Application for a Non-Material Amendment Following a Grant of Planning Permission

Removal of single storey rear projection. Construction of single storey rear extension. Alterations to 2 front dormers to make into 1 dormer.
Change position of
front door. New ground floor front and rear windows

3/23/0653/HH

New window to be fitted in side elevation of approved extension. Noted in Revision cloud on drawing

DRAWING TITLE:
**PROPOSED PLANS AND
ELEVATIONS**

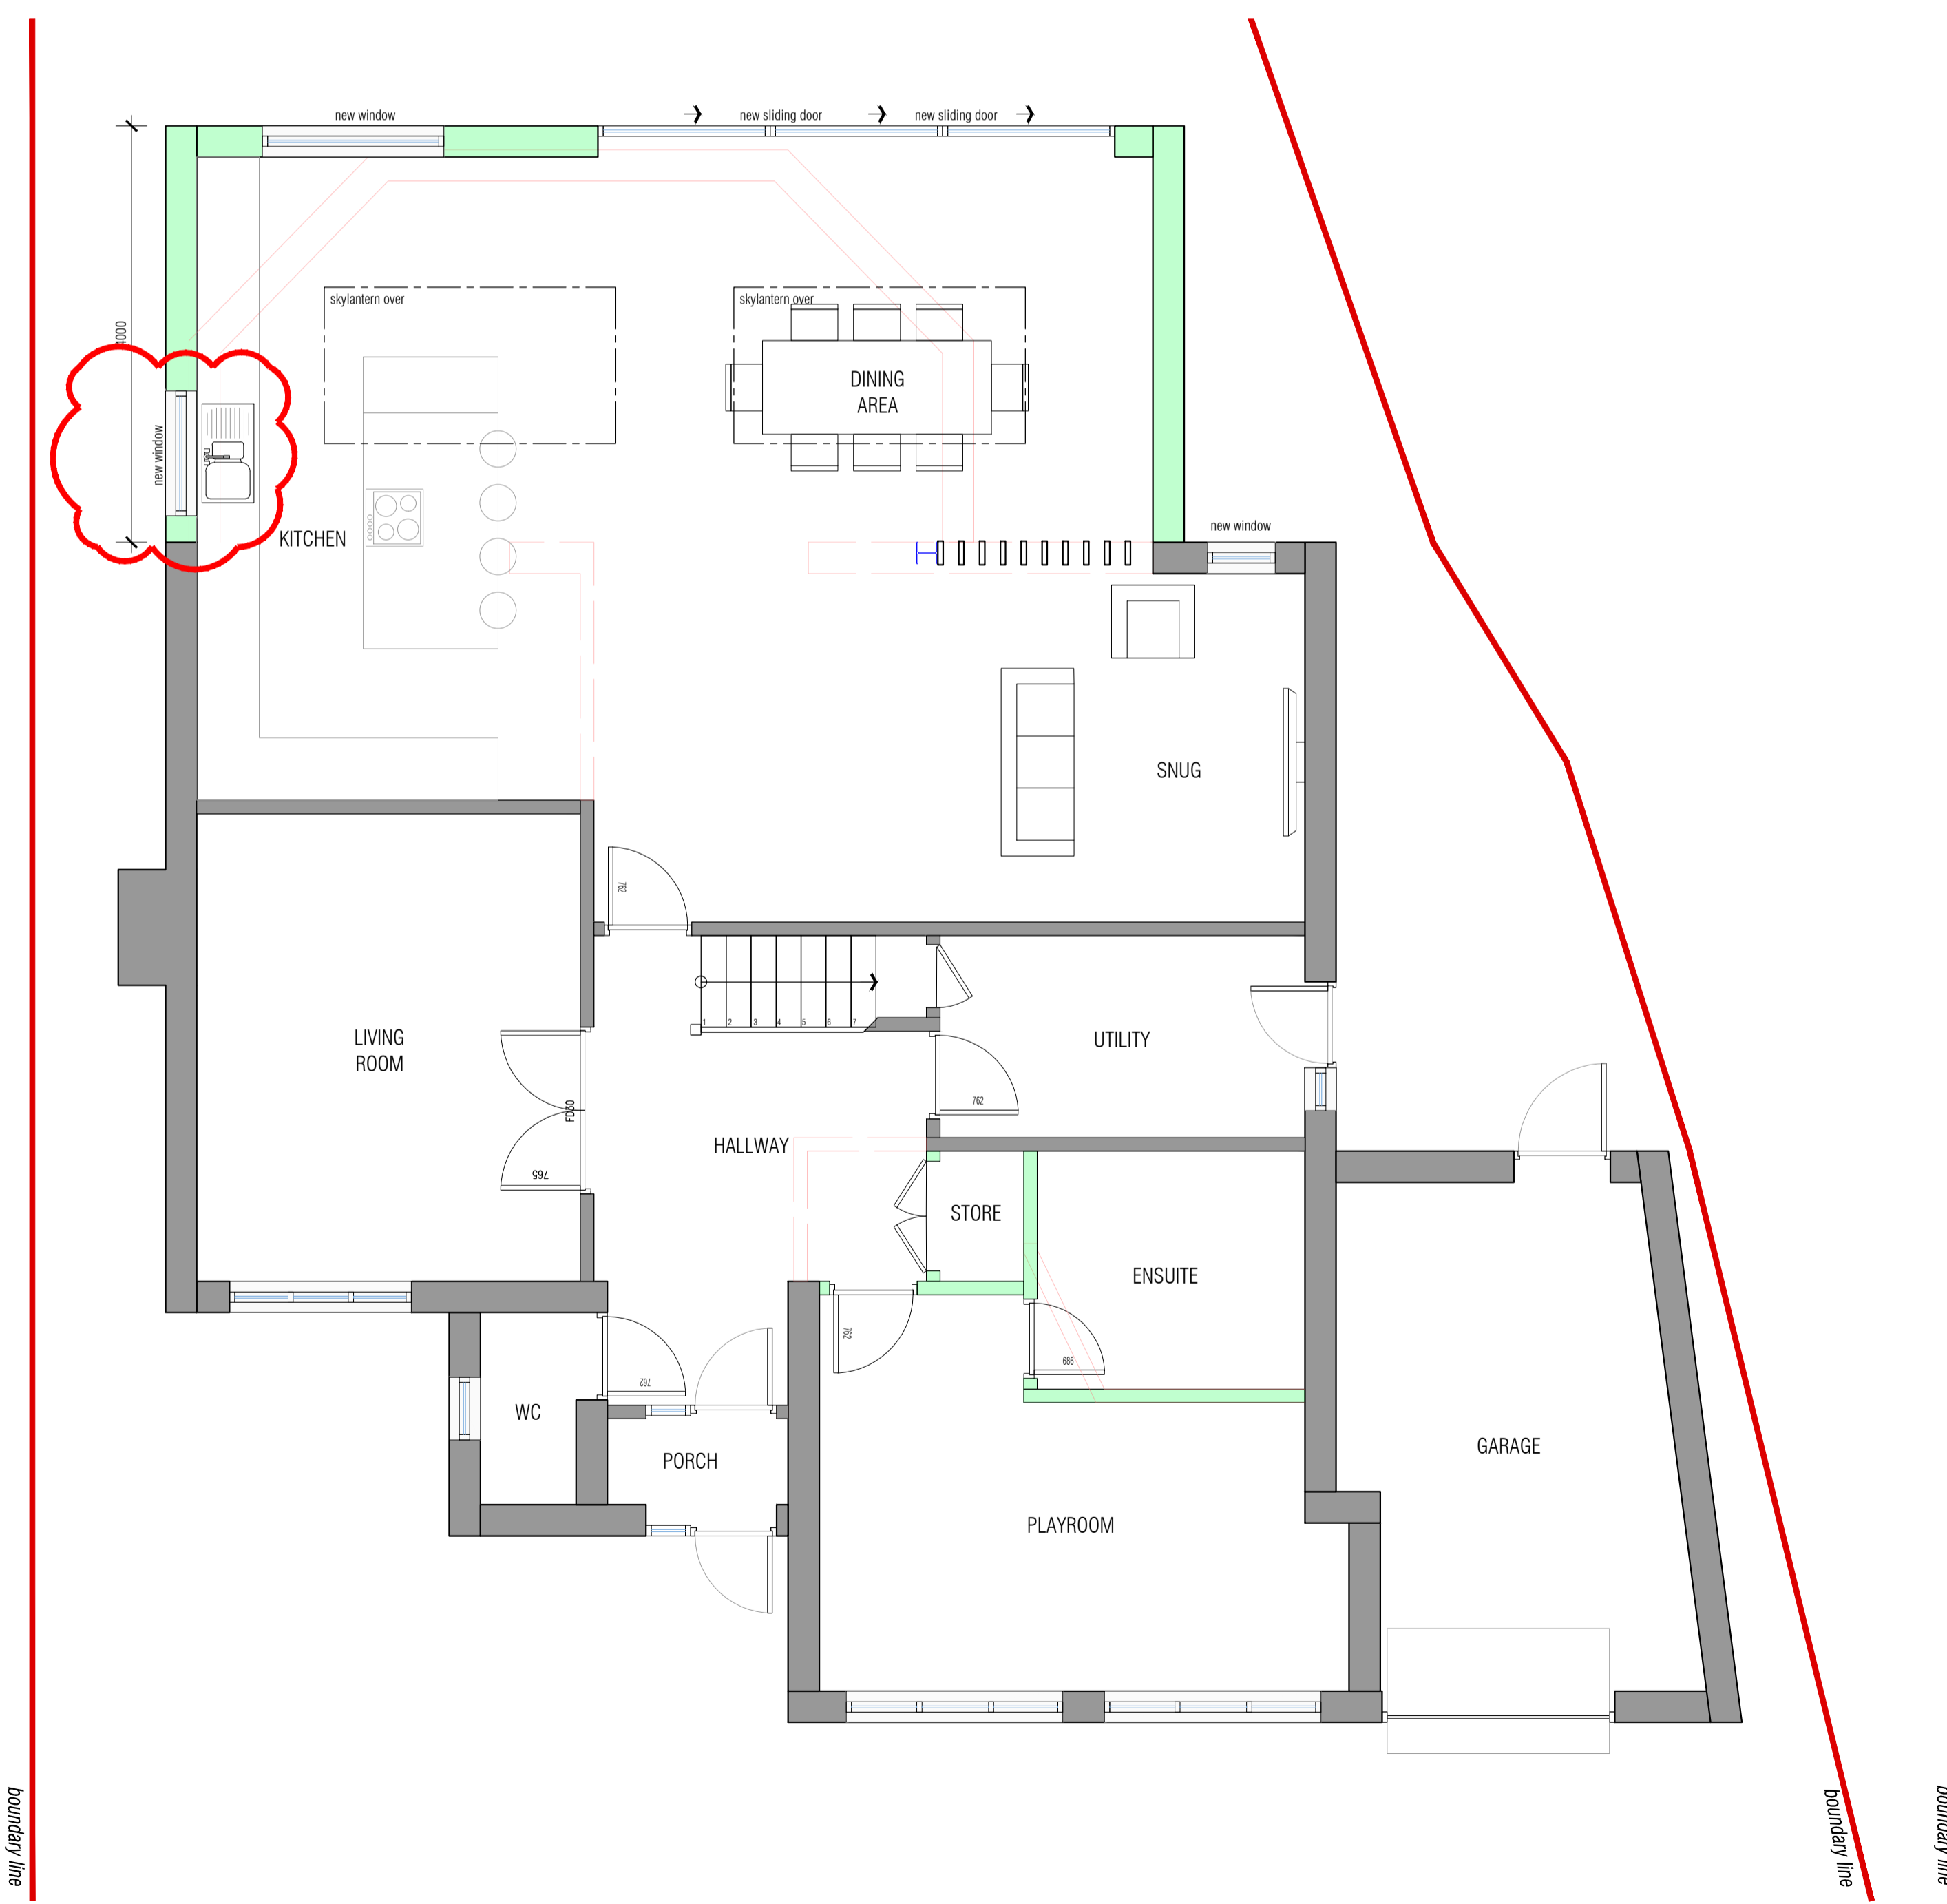
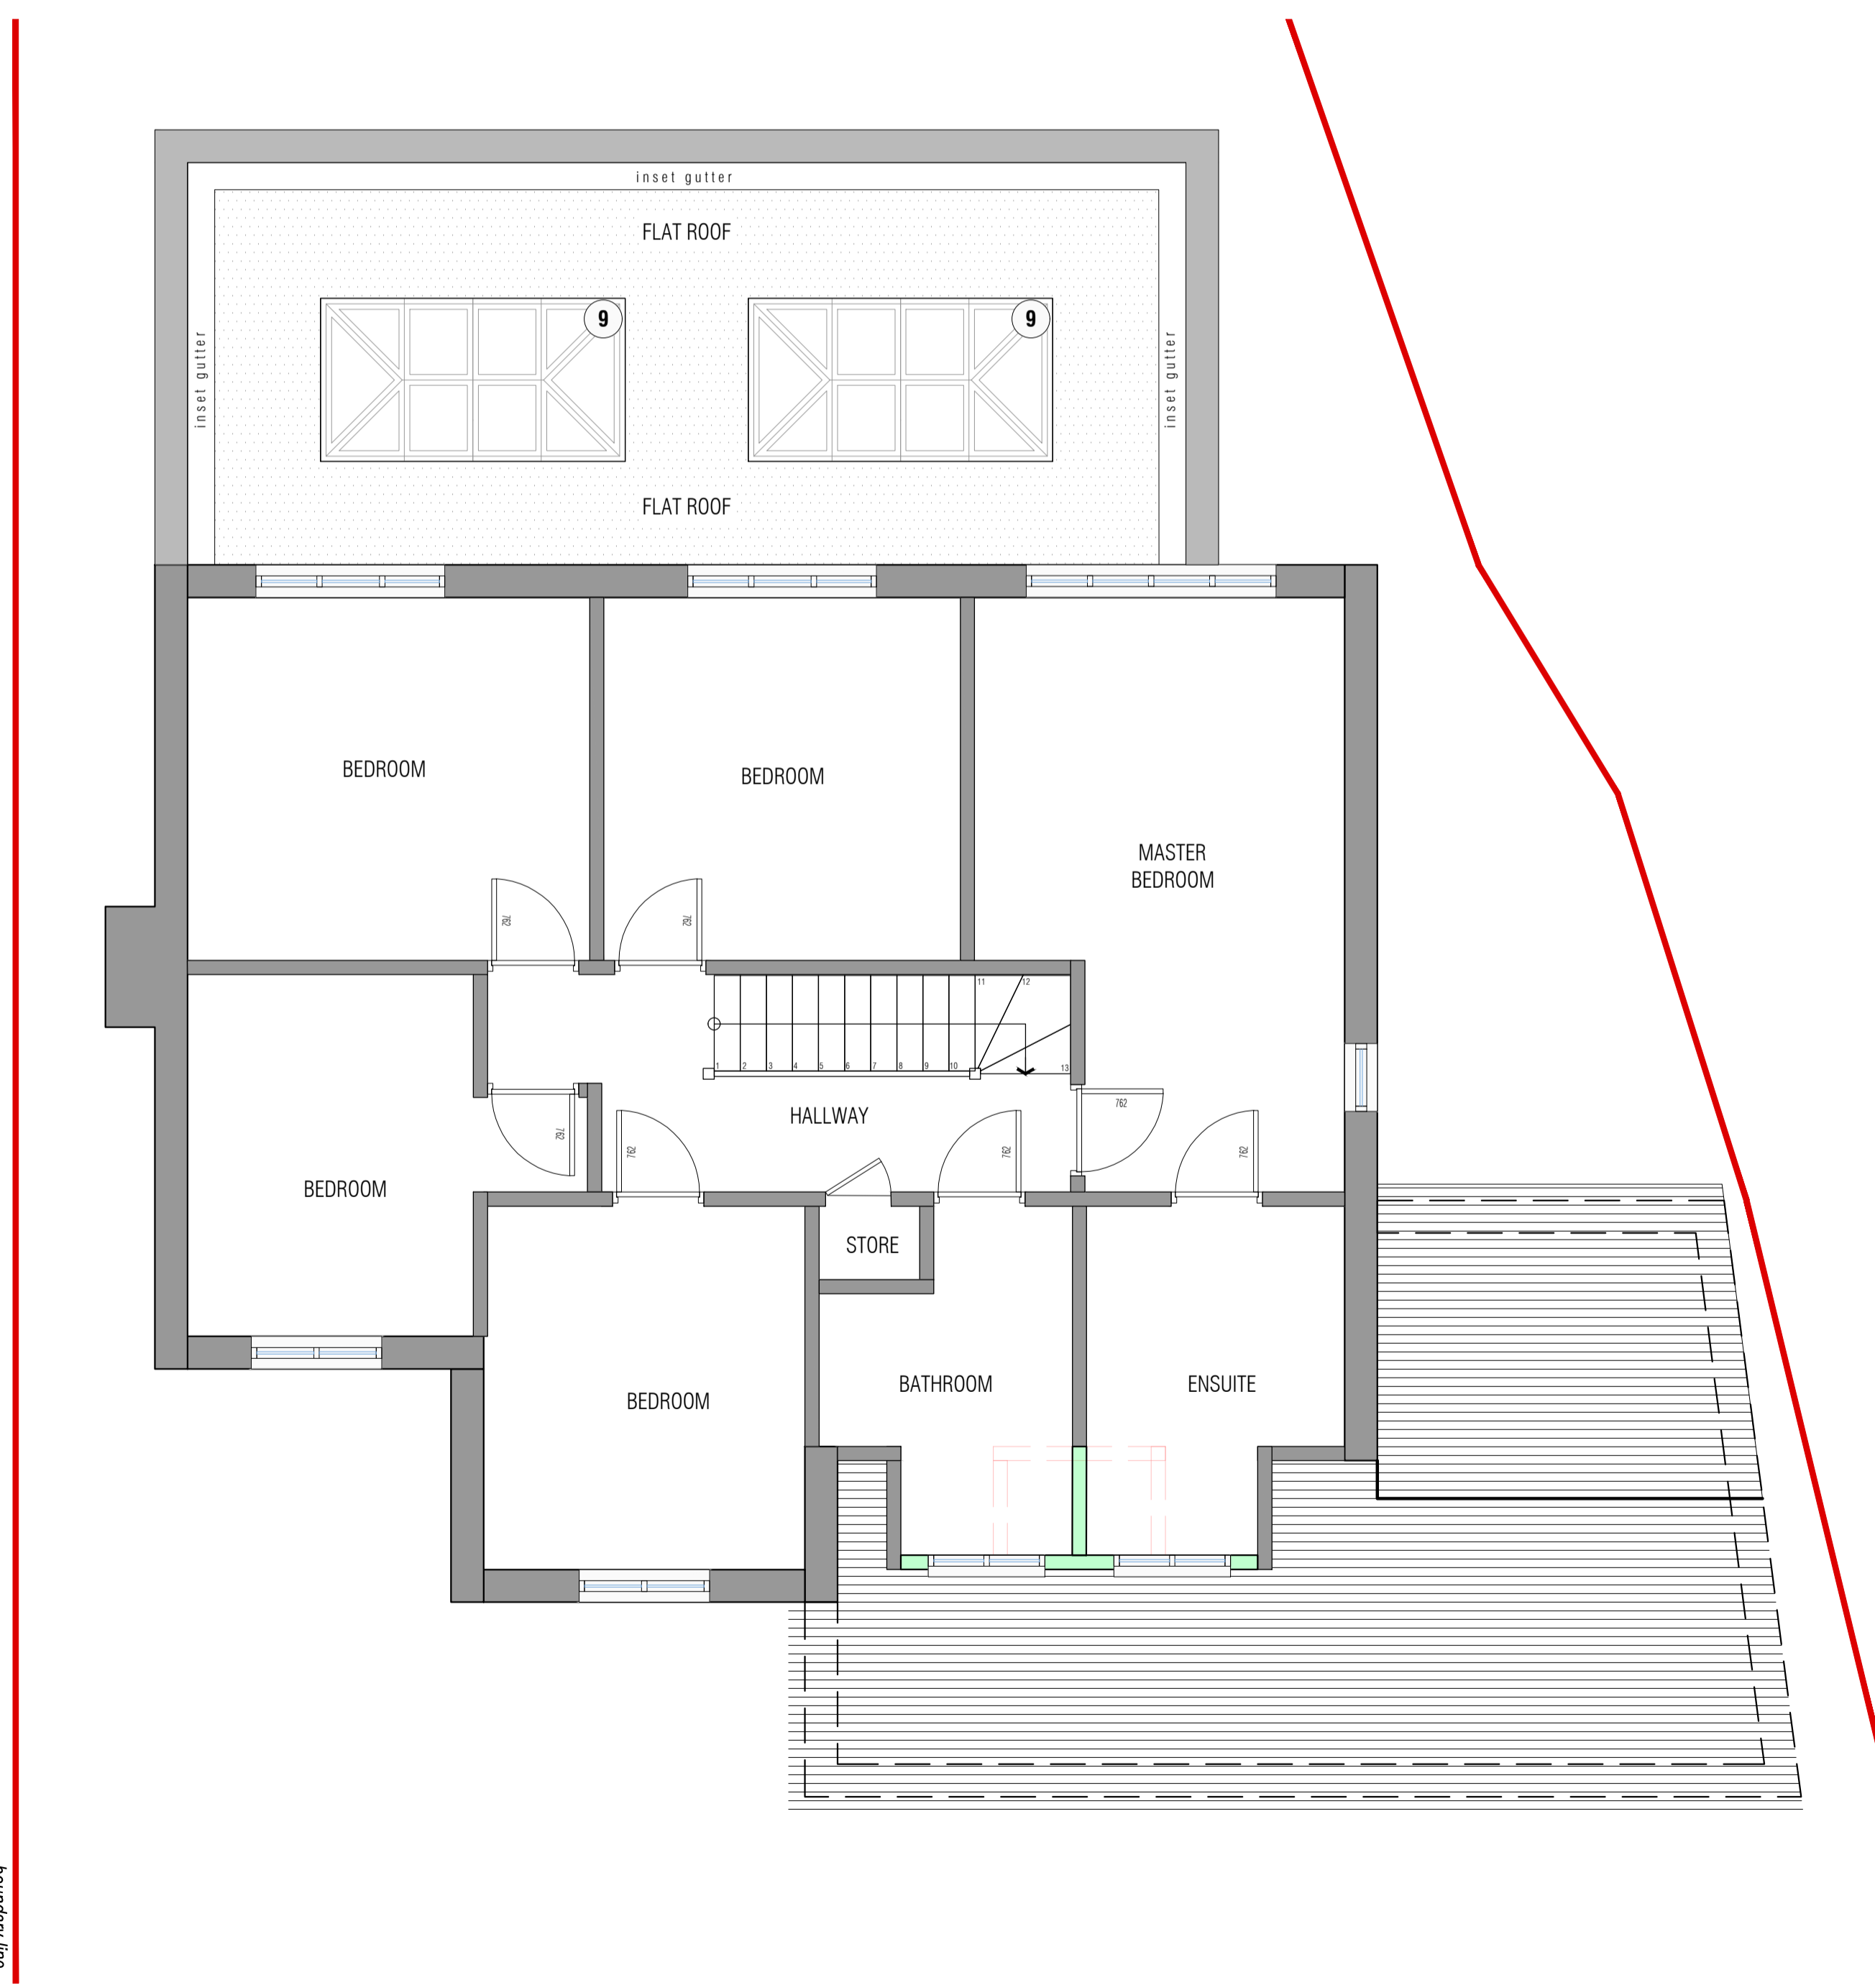
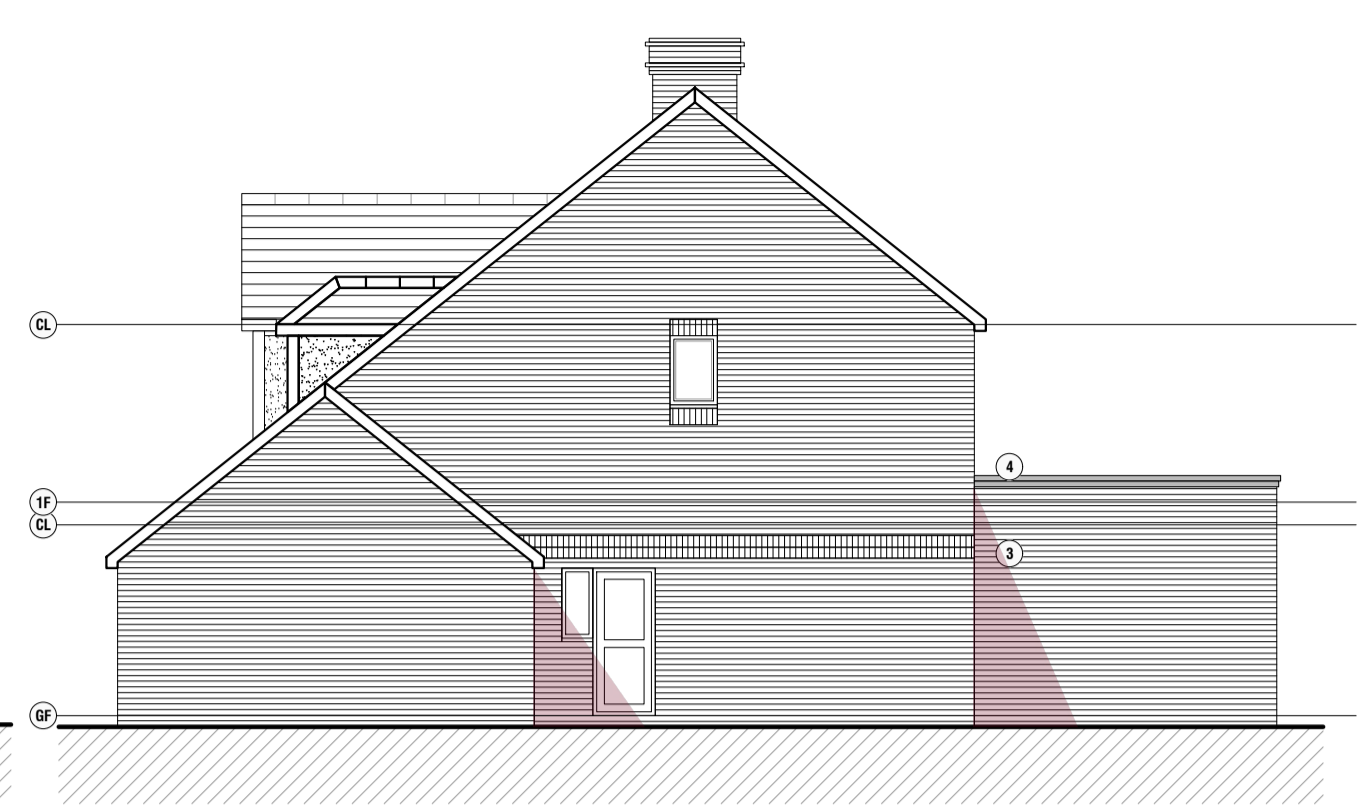
3665-23A1-03C PROPOSED PLANS AND ELEVATIONS

3665-23A1-03D PROPOSED PLANS AND ELEVATIONS
